SPRINGS AT WATERVIEW PRELIMINARY PLAN

LOCATED IN THE NW 1/4 OF SECTION 7, T15S, R65W OF THE 6TH P.M.,
EL PASO COUNTY, STATE OF COLORADO

DSE Dakota Springs Engineering
31 N. TEJON, SUITE 500
COLORADO SPRINGS, CO 80903
P: (719) 227-7388
F: (719) 227-7392
PROJECT **SPRINGS AT WATERVIEW**
SHEET TITLE **TITLE SHEET**
FROM _____ TO _____
JOB NO. **021601** SHEET **1** OF **3**

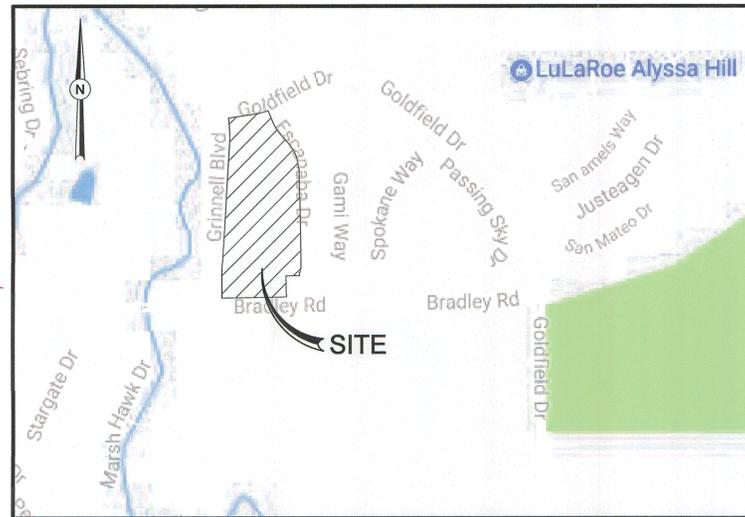
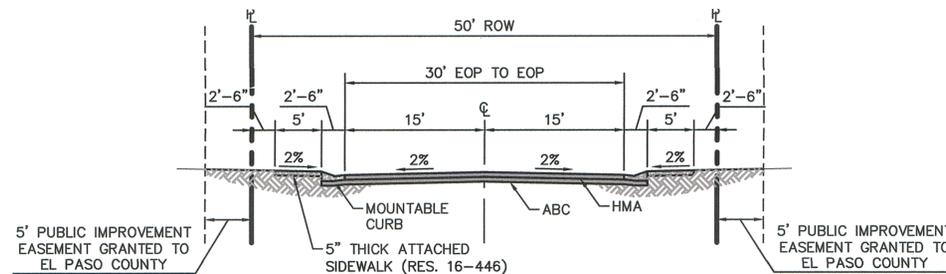
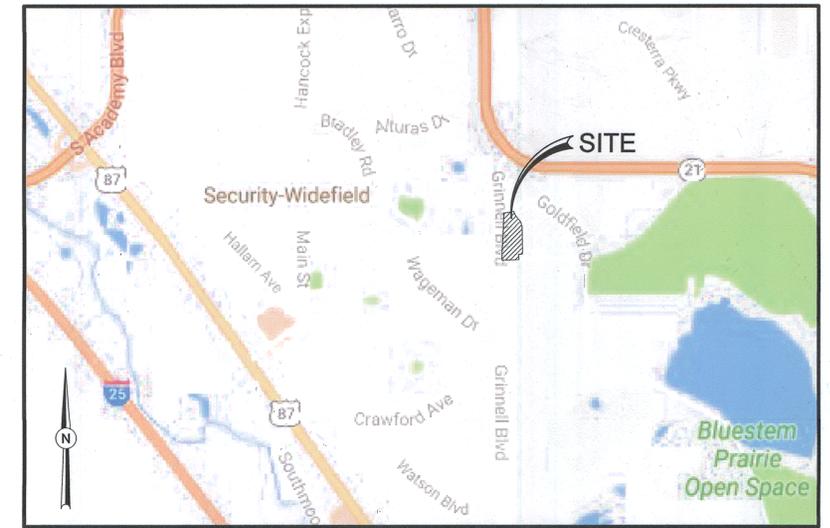
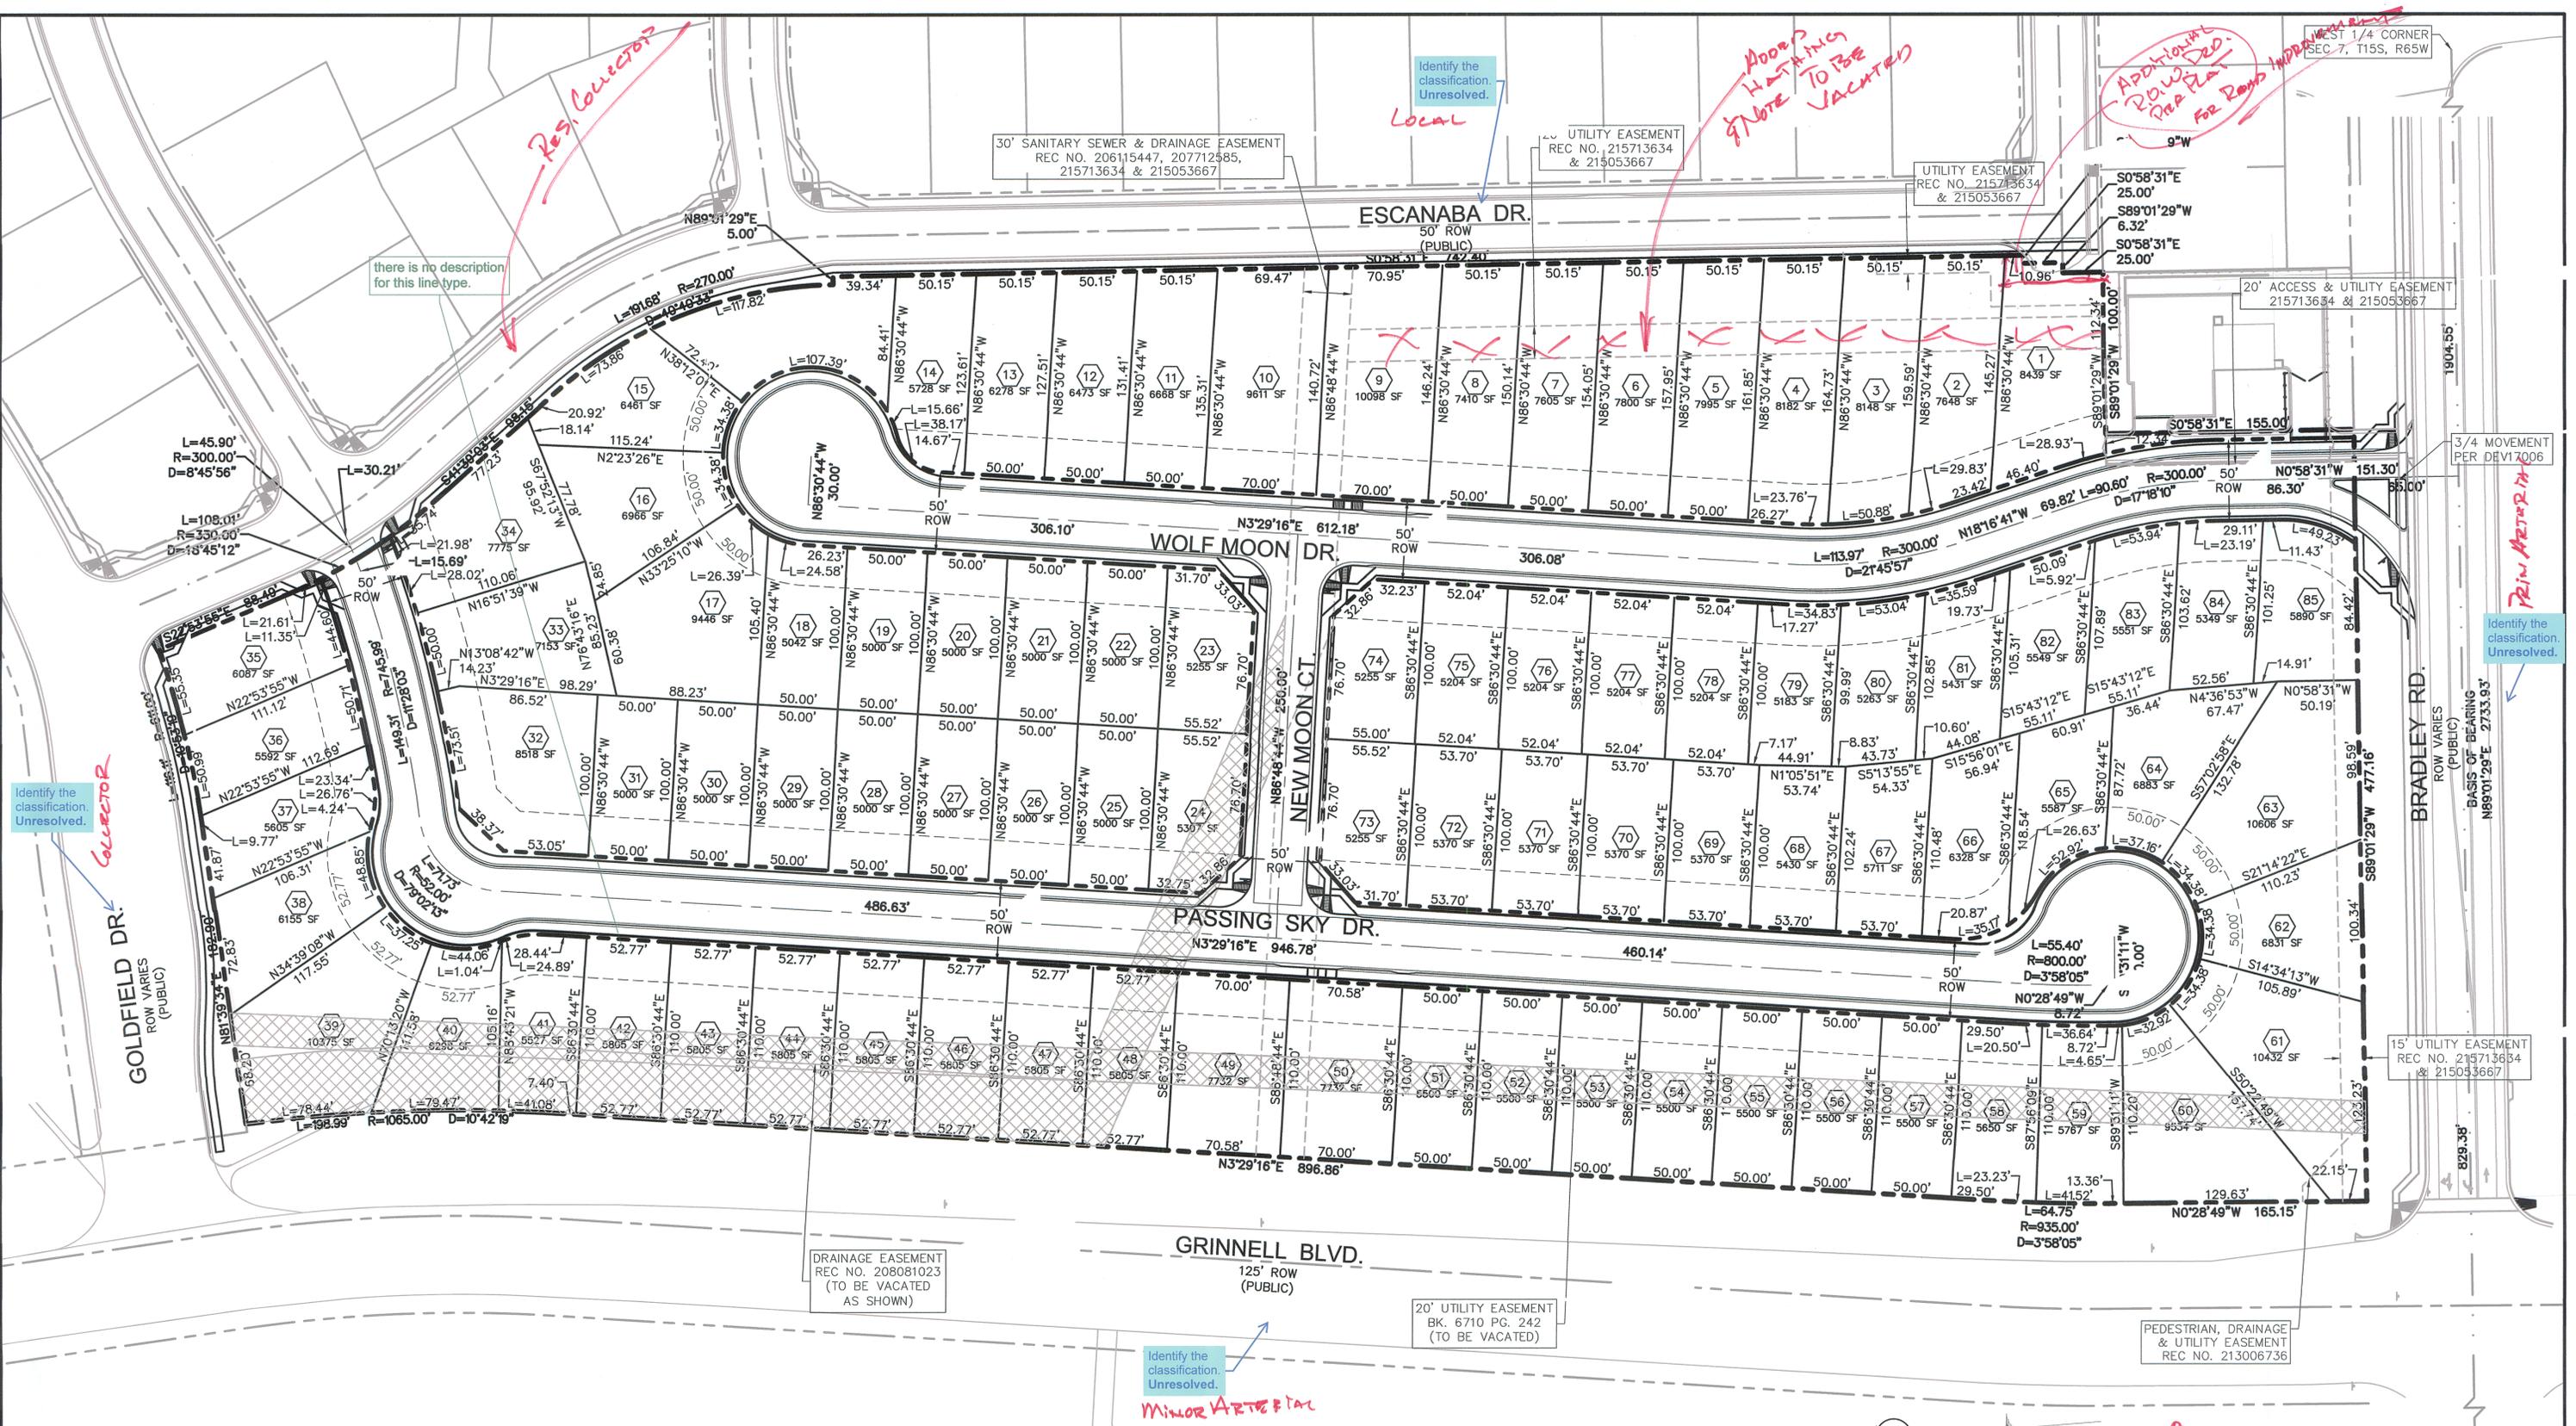
Provide the specific FEMA FIRM Panel No.

Add notes:
1. There shall be no direct lot access to Grinnell Blvd, Brady Road, Goldfield Drive, and New Moon Drive.
2. Reference the approved deviation request for the 3/4 movement on Bradley Road

not formatted properly

add standard easements.

Identify as 5' thick sidewalk per Resolution 16-446

Revise to "Public Improvement Easement granted to El Paso County"

Identify as Urban Local Roadway Cross Section Note the specific proposed roadways this applies to.

PROJECT SPRINGS AT WATERVIEW  
 SHEET TITLE SITE PLAN  
 FROM   TO    
 JOB NO. 021601 SHEET 2 OF 3

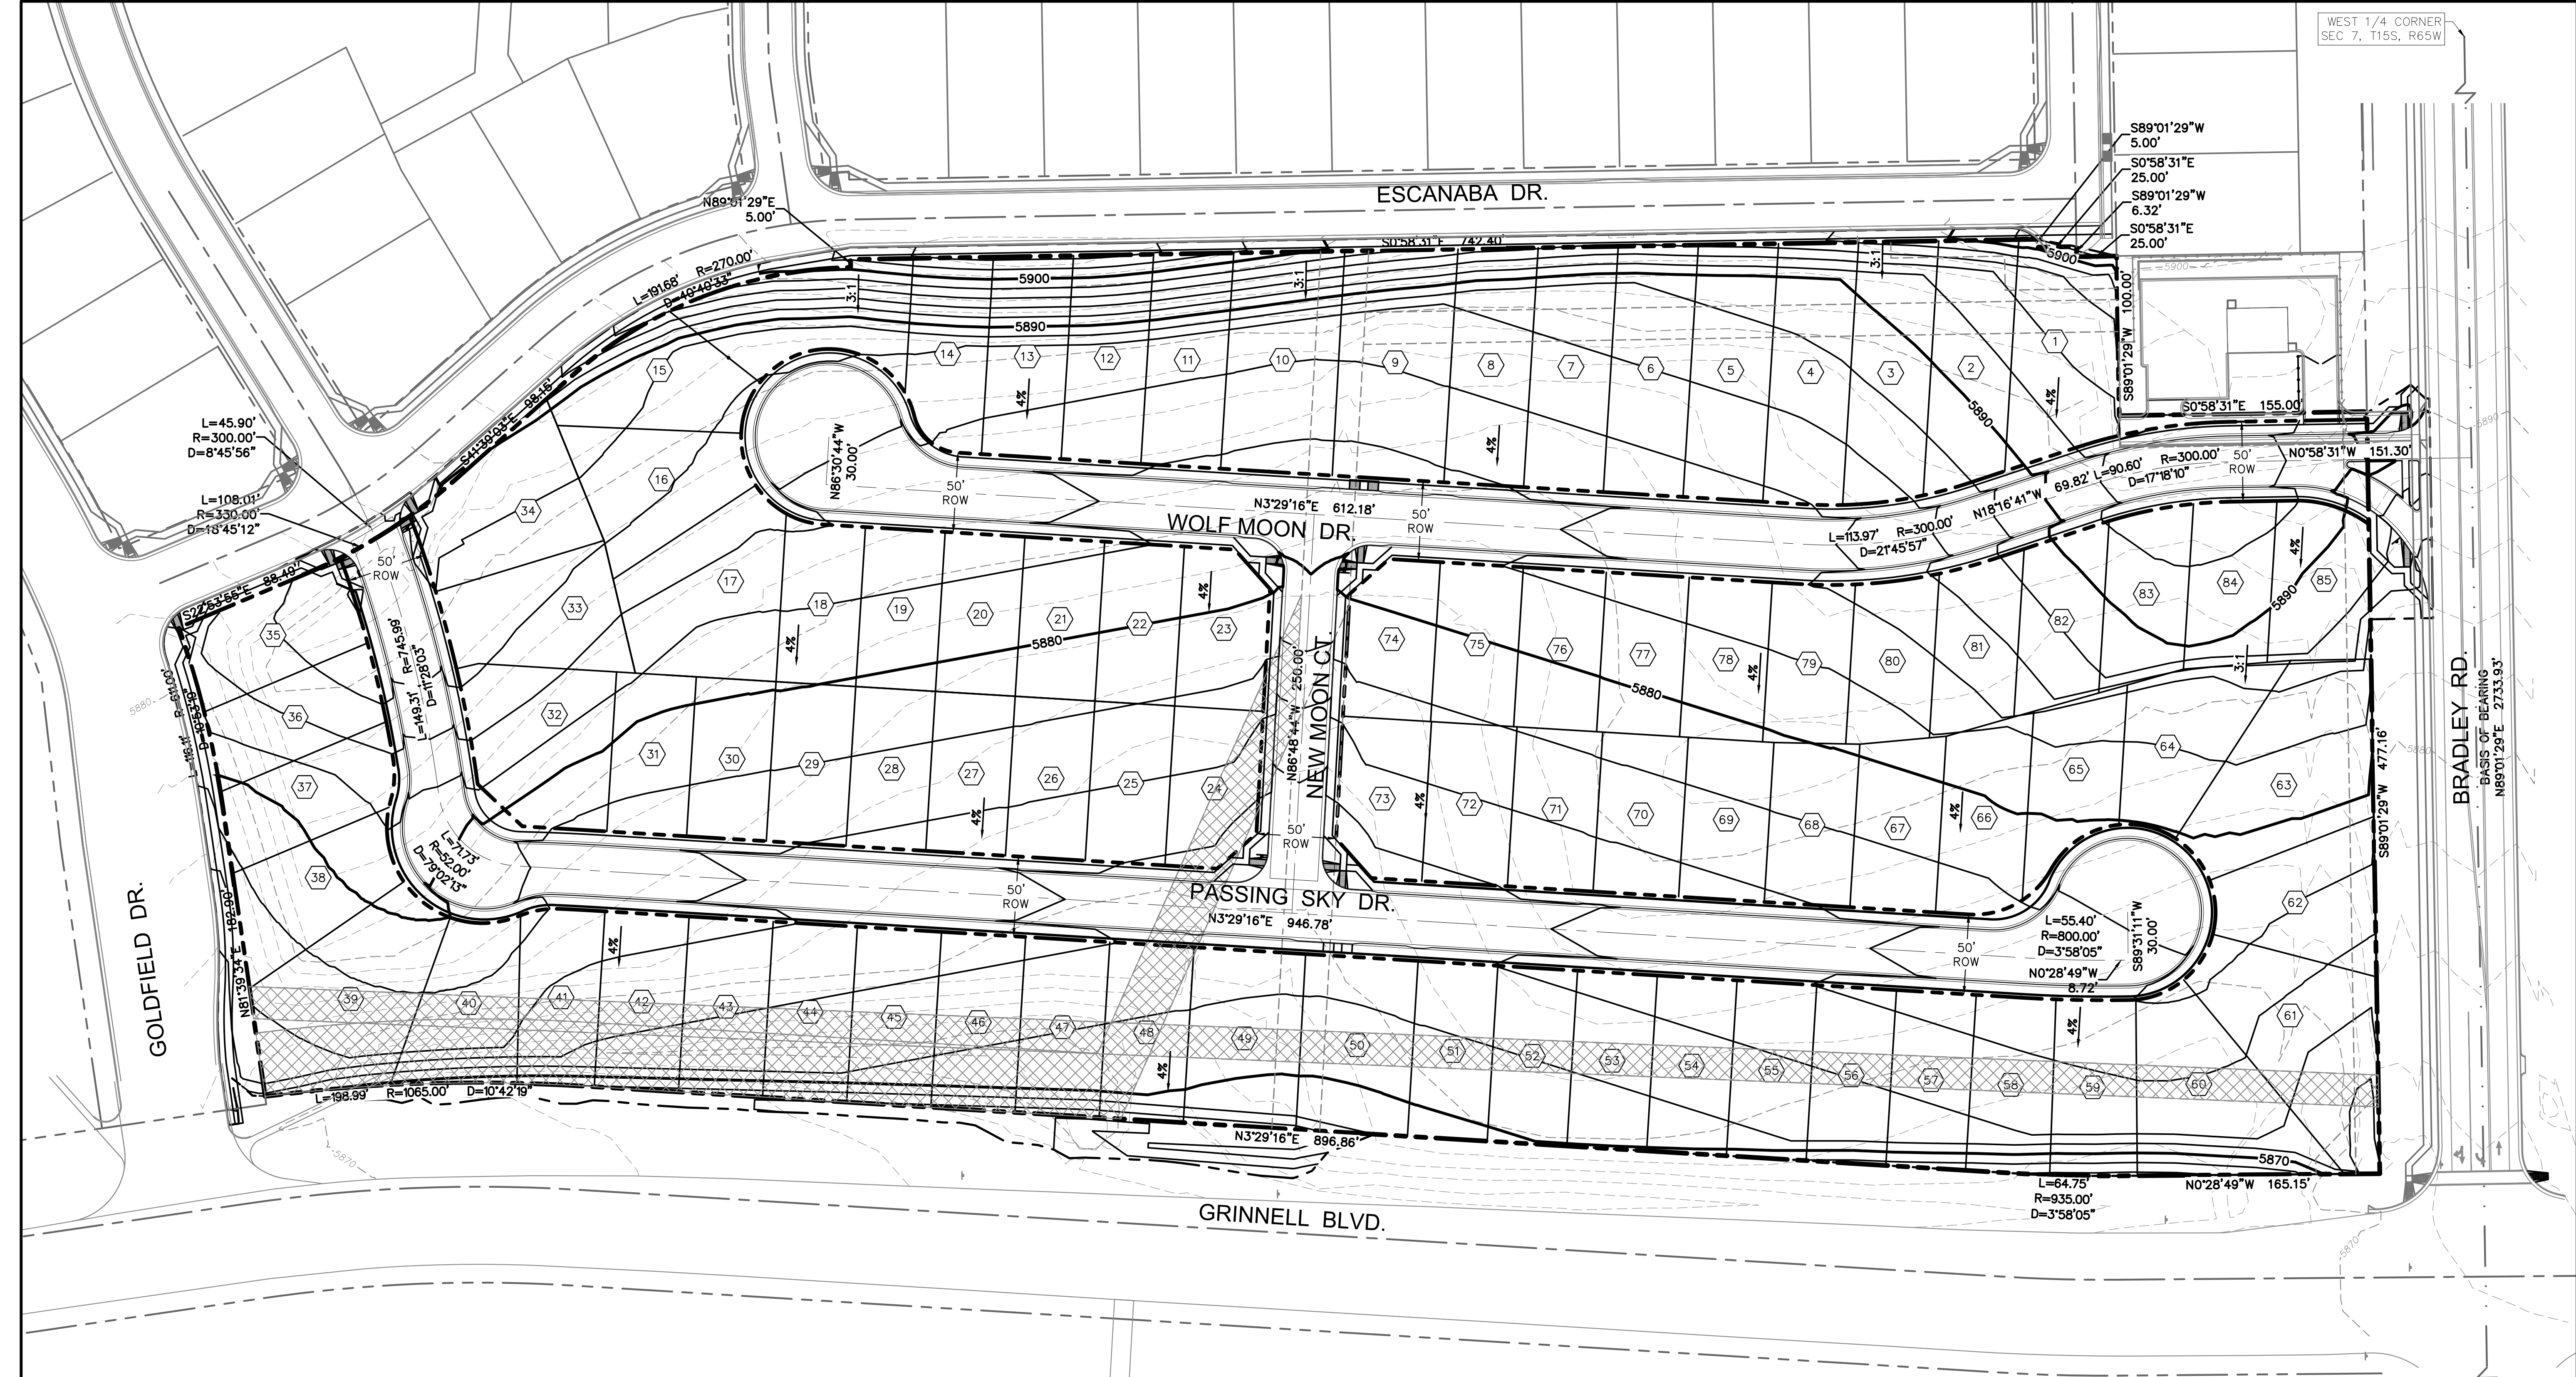
Add a note that Lots 34 and 35 will have no direct lot access to Escanaba Dr.

Specify on the notes which street these lots which have their driveway access located.

Show the proposed pump station improvement. Callout the relocation of the driveway.

Identify as 3/4 movement

Identify the classification and ROW width

Note for no access.

For all lots that do not have 50' frontage please add a setback line to reflect where they are 50' in width.

Identify the classification and ROW width

Show the existing road linework
